From: Carol Reynolds
Sent: 28 June 2018 16:40
To: Planning.Responses
Cc: Sarah Meeten
Subject: FW: Planning Consultation on: R/105/18/PL

APPLICATION **R/105/18/PL**
NO:

Site Address: Sandon The Coppice Rustington BN16 3TP

Description of Works: Change of use of integral garage to form treatment/waiting room, 2 No. dormers to first floor front extension, replacement of rear dormer with 1 No. velux window, balcony to side, change of side window to window & door & 1 No. additional velux to ensuite (amendment to R/45/17/PL).

PROPOSED GROUND FLOOR PLAN

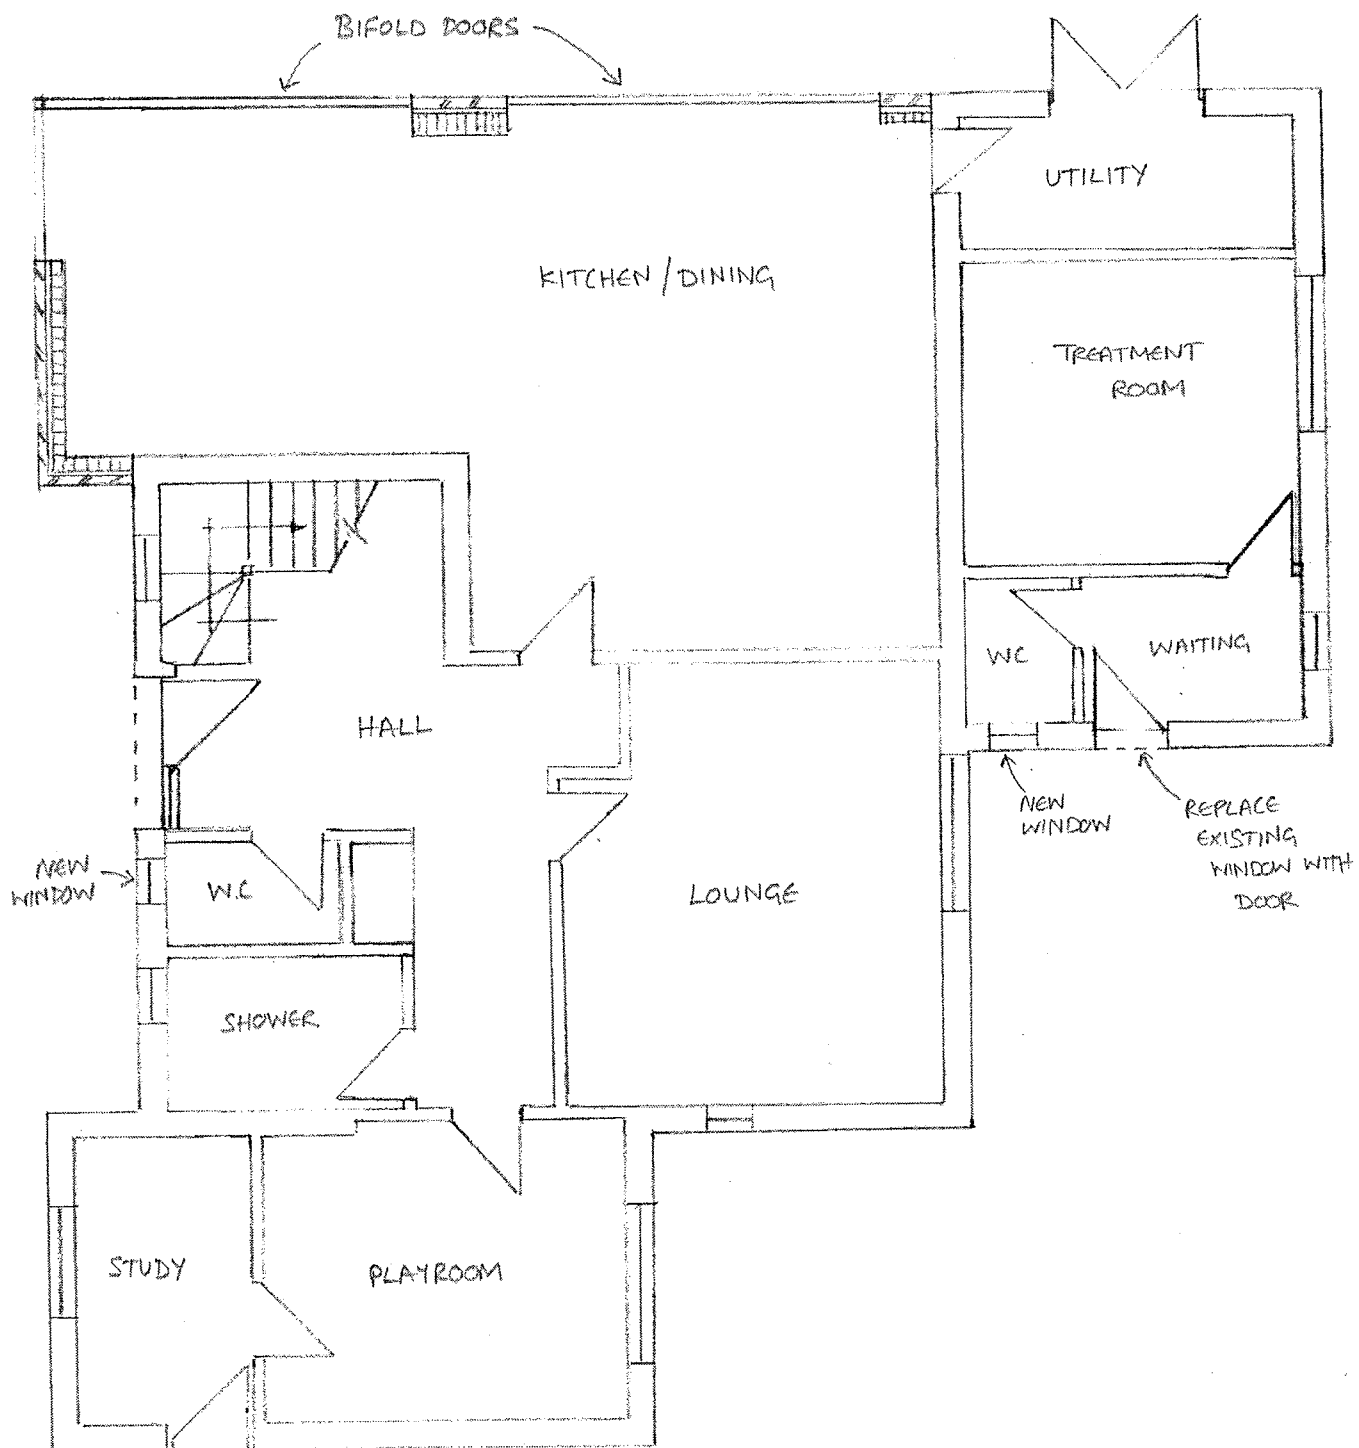
*The applicant is advised of Arun District Council's 'Byelaws with Respect to Acupuncture, Tattooing, Semi-Permanent Skin-Colouring, Cosmetic Piercing and Electrolysis' in respect of necessary measures to secure the cleanliness of premises, fittings (and persons) engaged for these purposes. Please note that a suitable sink and wash hand basin together with hot and cold water, or water of a suitably controlled temperature and proper drainage should be provided within the treatment room.
